CITY OF ALBUQUERQUE

**Planning Department
Transportation Development Services Section**

Re: Certification Submittal for Final Building Certificate of Occupancy for
Professional Auto Wholesale, [M-10 / D16D]
7011 Huseman Place NW
Engineer's Stamp Dated 10/12/06

**RE: TRAFFIC CERTIFICATION FOR PROFESSIONAL AUTO WHOLESALE;
LOT 8, COORS-ARENAL INDUSTRIAL PARK SUBDIVISION (M10-D16D)**

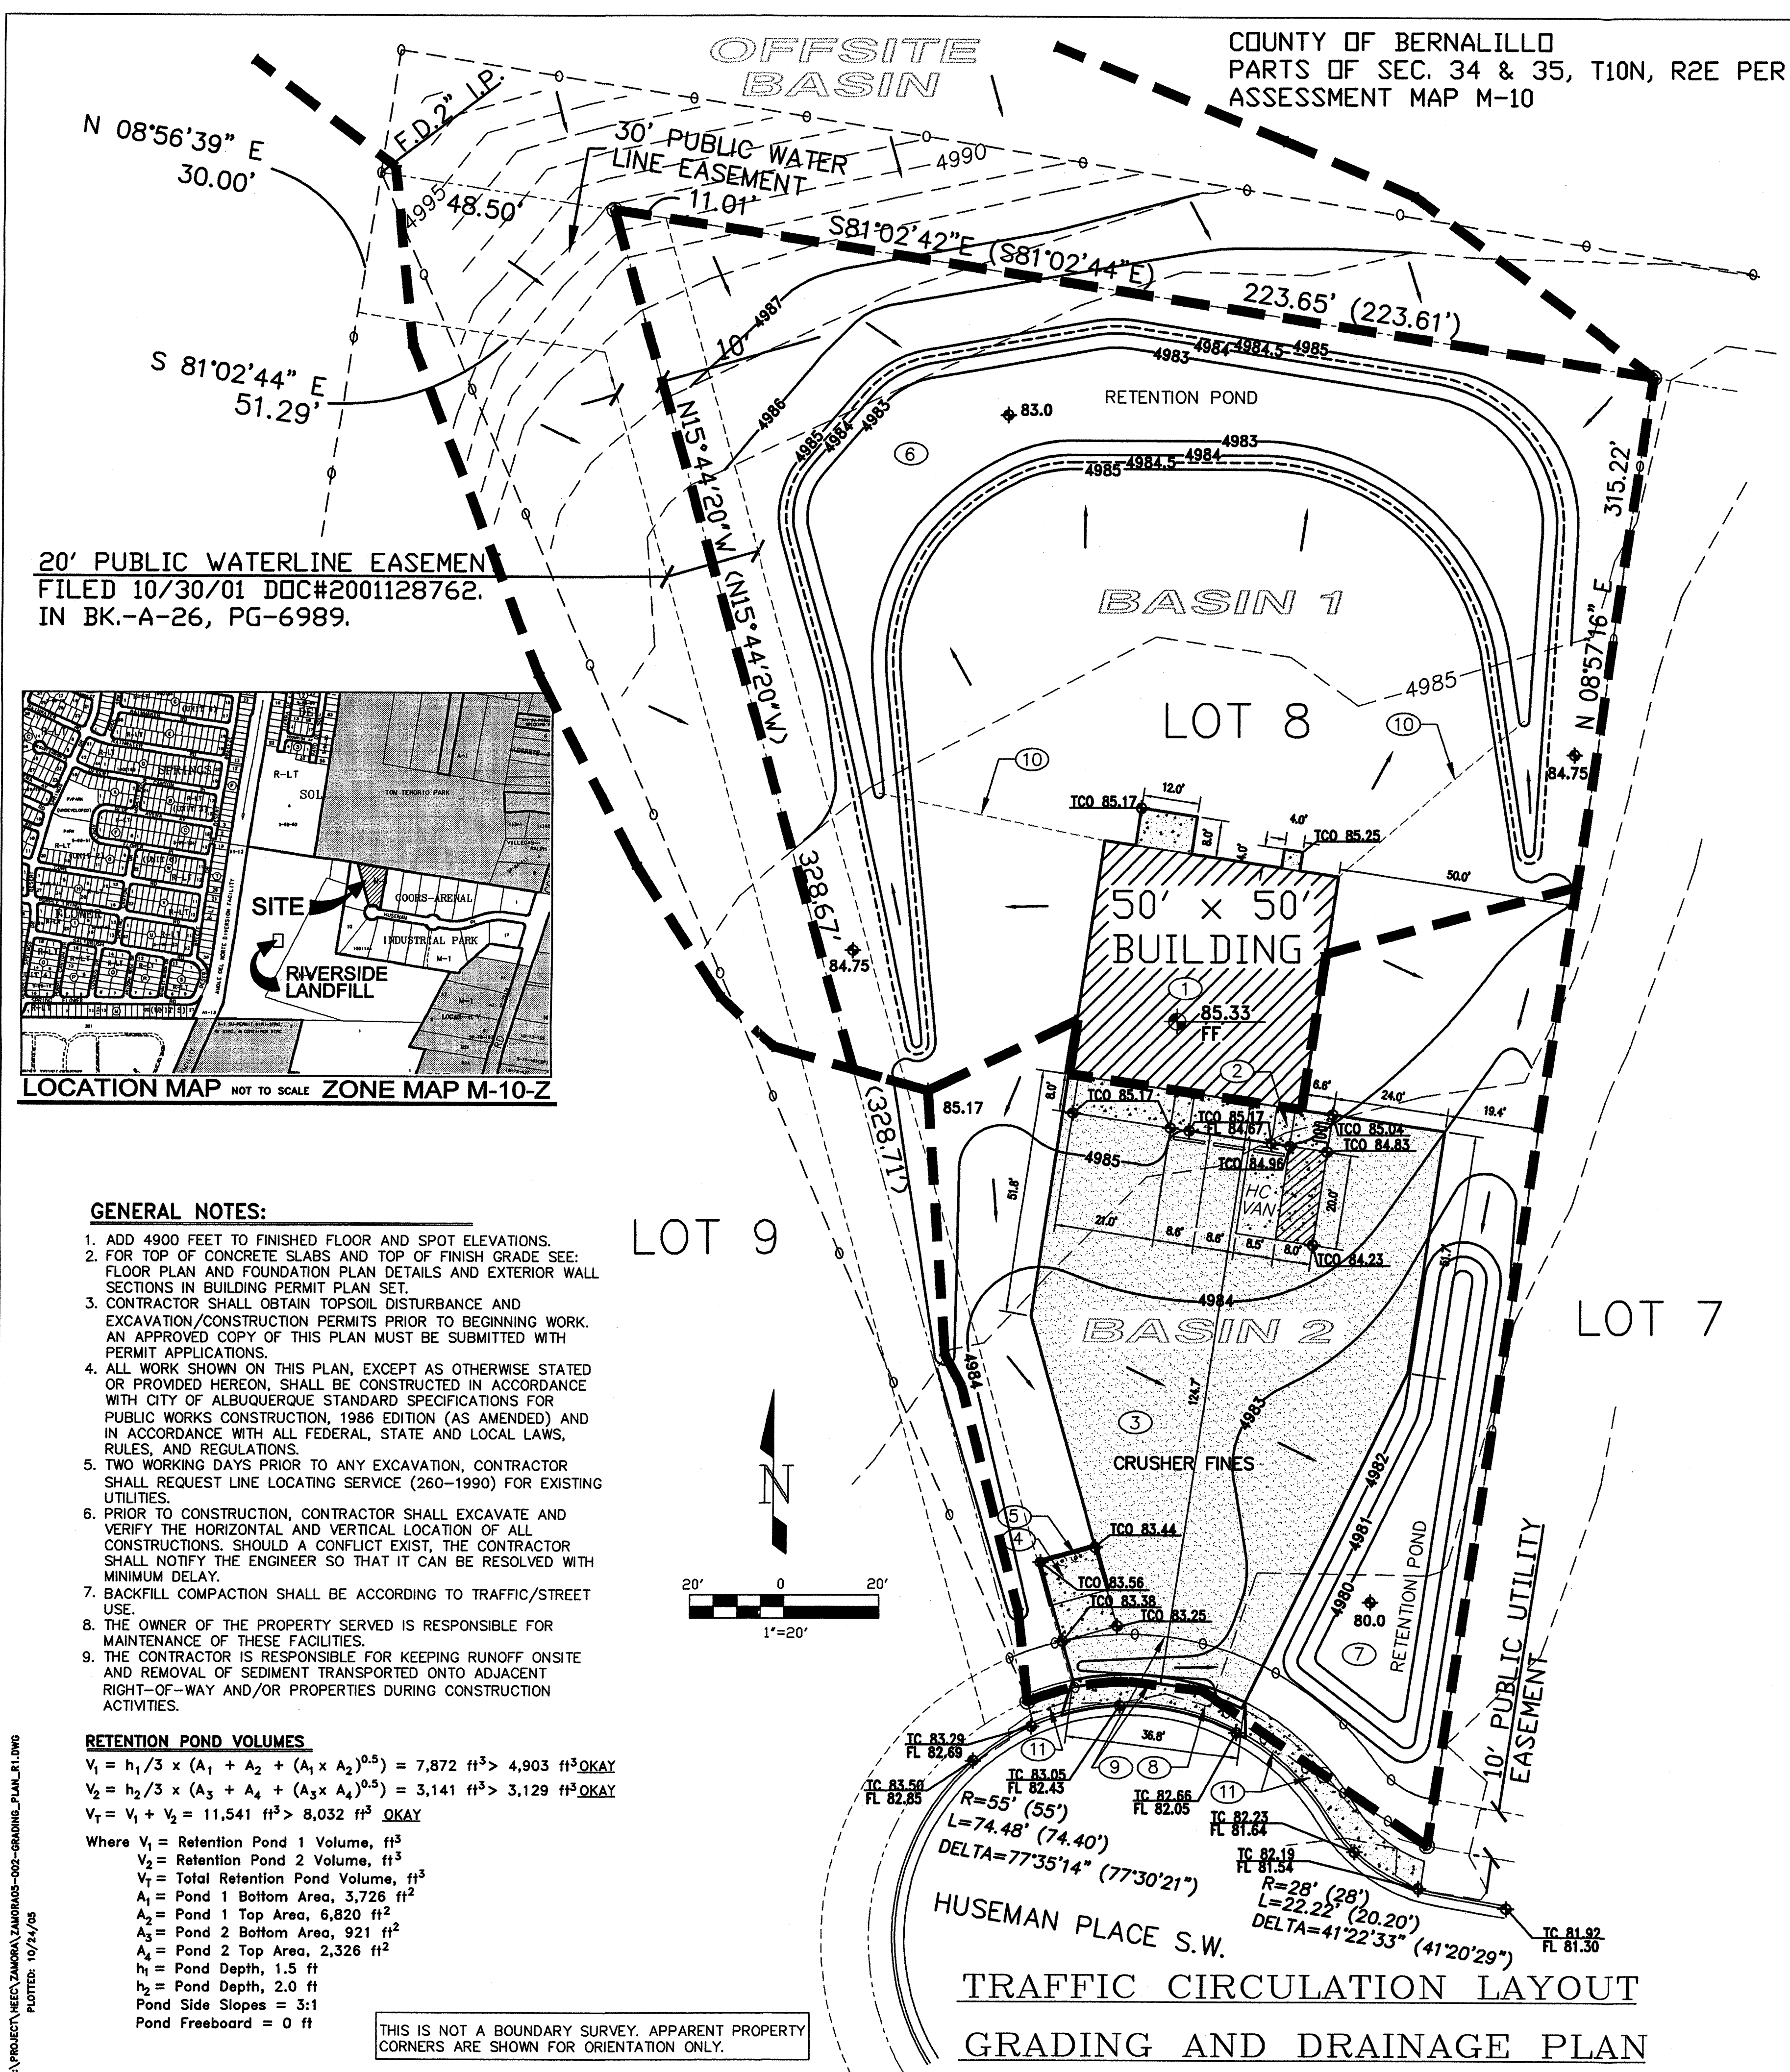
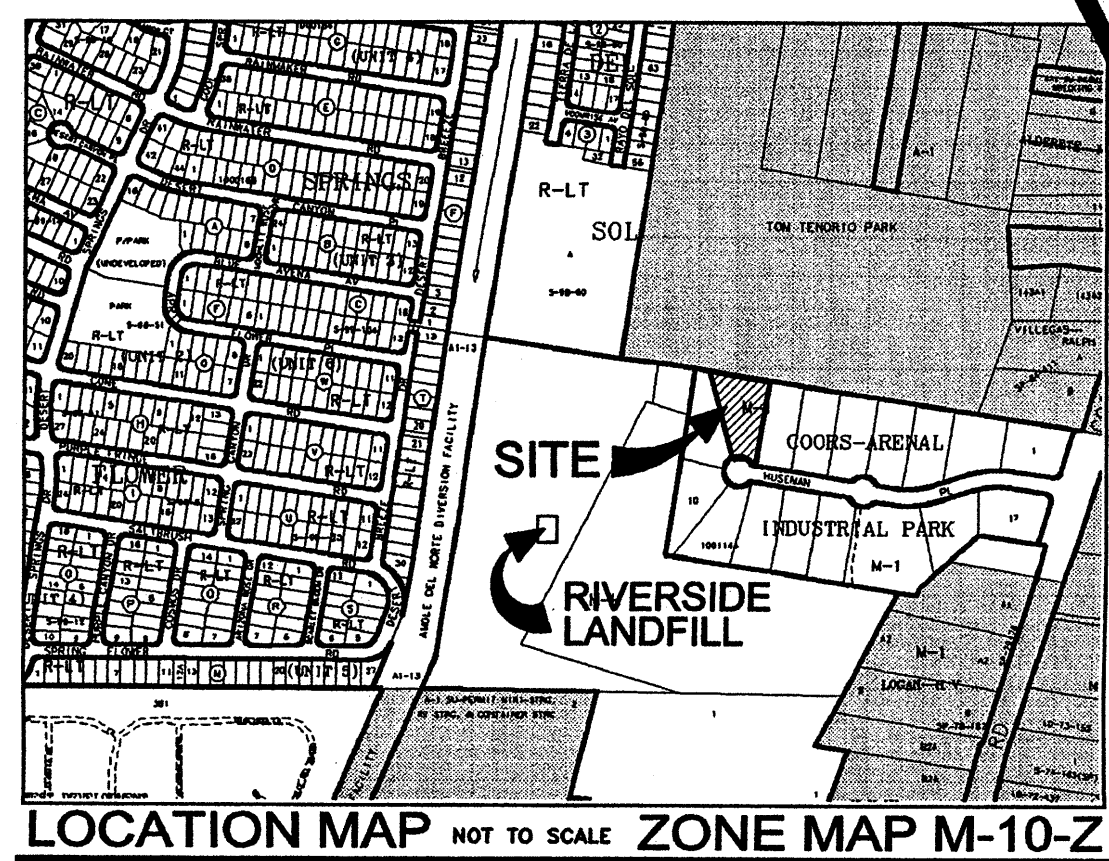
- Provide a new 6' sidewalk along the sites frontage with Huseman Place.

SIZE D	FSCM NO.	DWG NO. ZAMORA05-002-GRADING_PLAN_R1.dwg	REV 1
SCALE 1"=20'	DRAWN BY: RG/JLH	SHEET

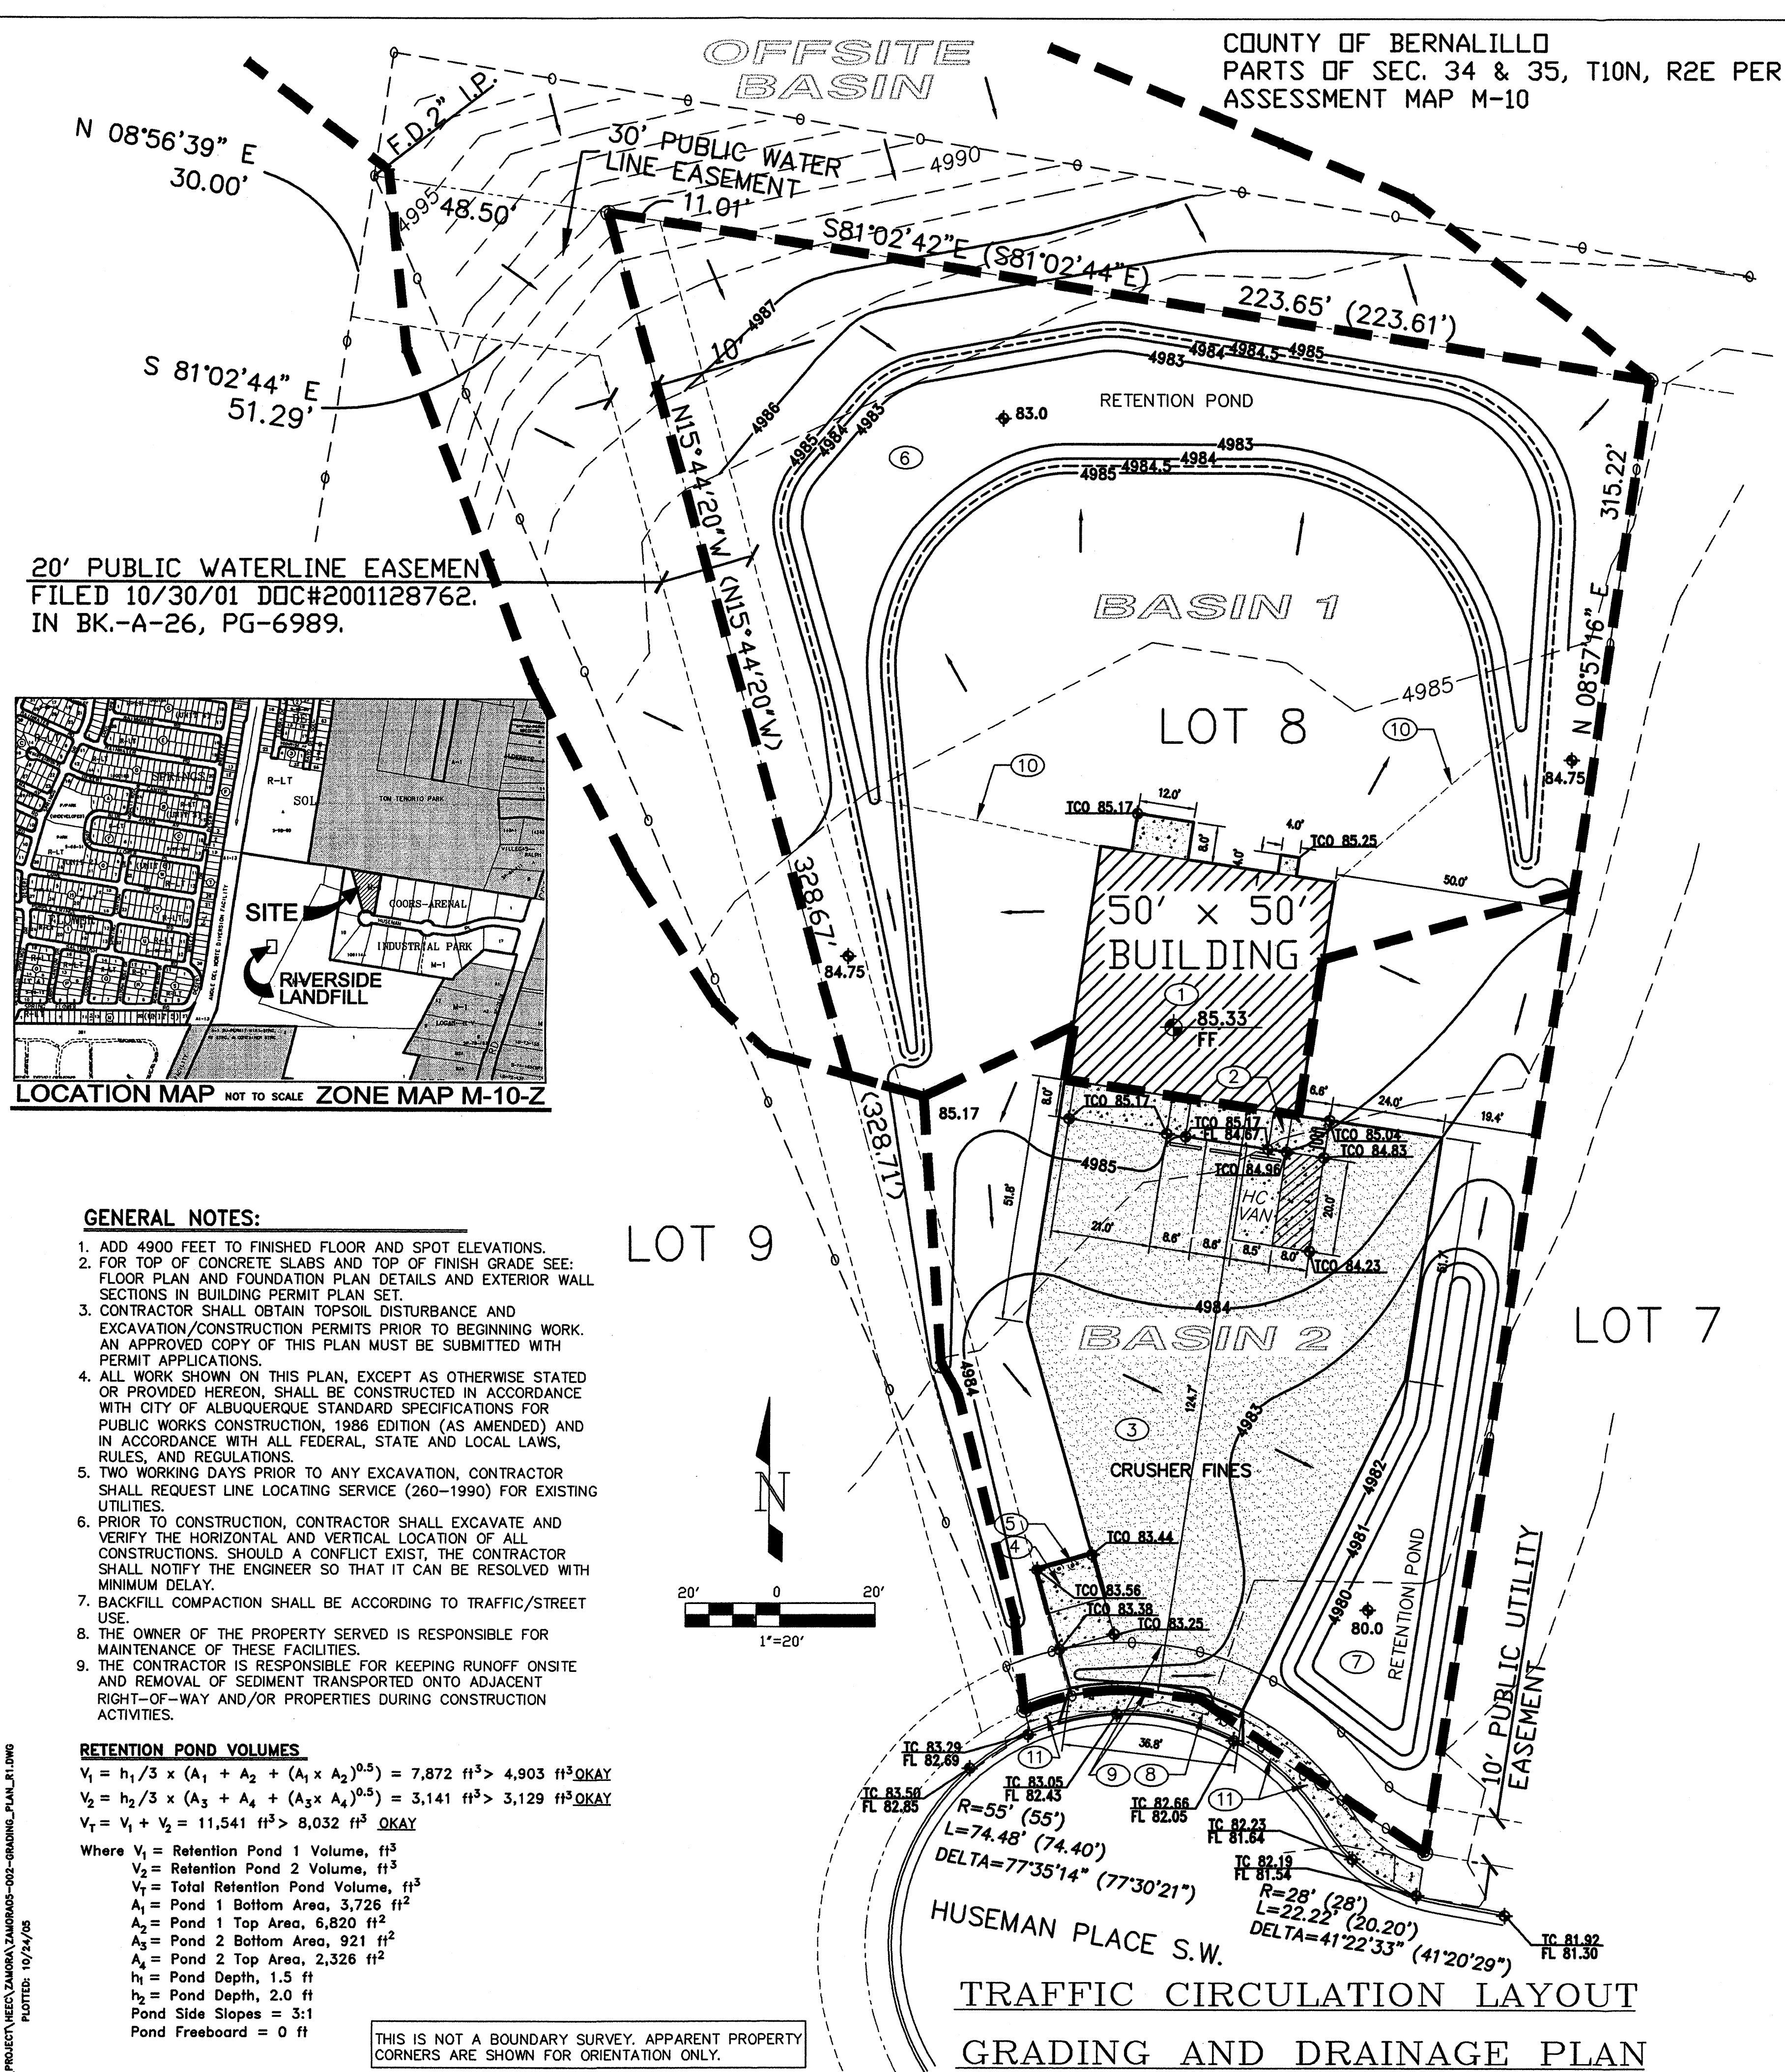
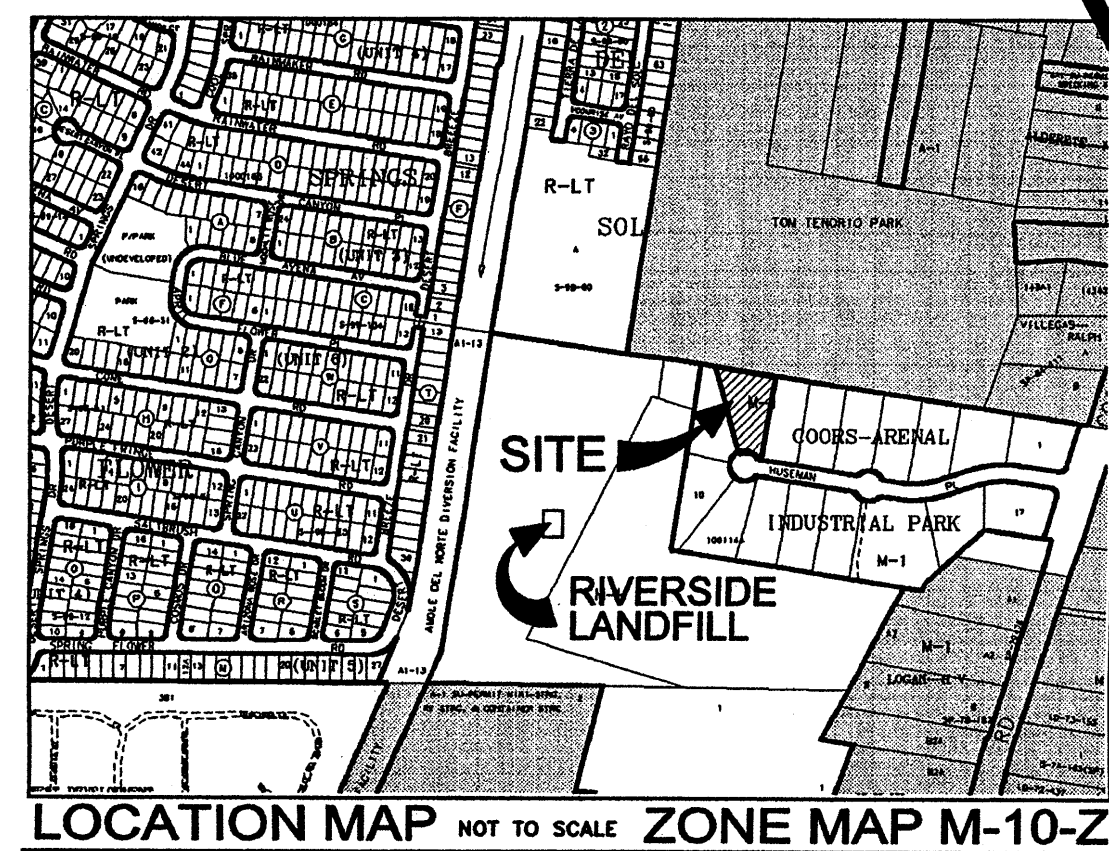
Based upon the information provided in your submittal dated 9-27-05, the above referenced plan cannot be approved for Building Permit until the following comments are addressed:

- Delineate drainage basin areas for each retention pond and provide volume calculations for each basin separately. ✓
- Provide additional spot elevations to clarify how site runoff drains to each retention pond. ✓
- Check 4985 contour around Retention Pond 2. It cannot be a closed contour and also connected to the existing 4985 contour. ✓
- Provide existing spot elevations at curb and gutter flow line along sites frontage with Huseman Place. ✓
- Provide the recorded Private Facility Drainage Covenant. ✓
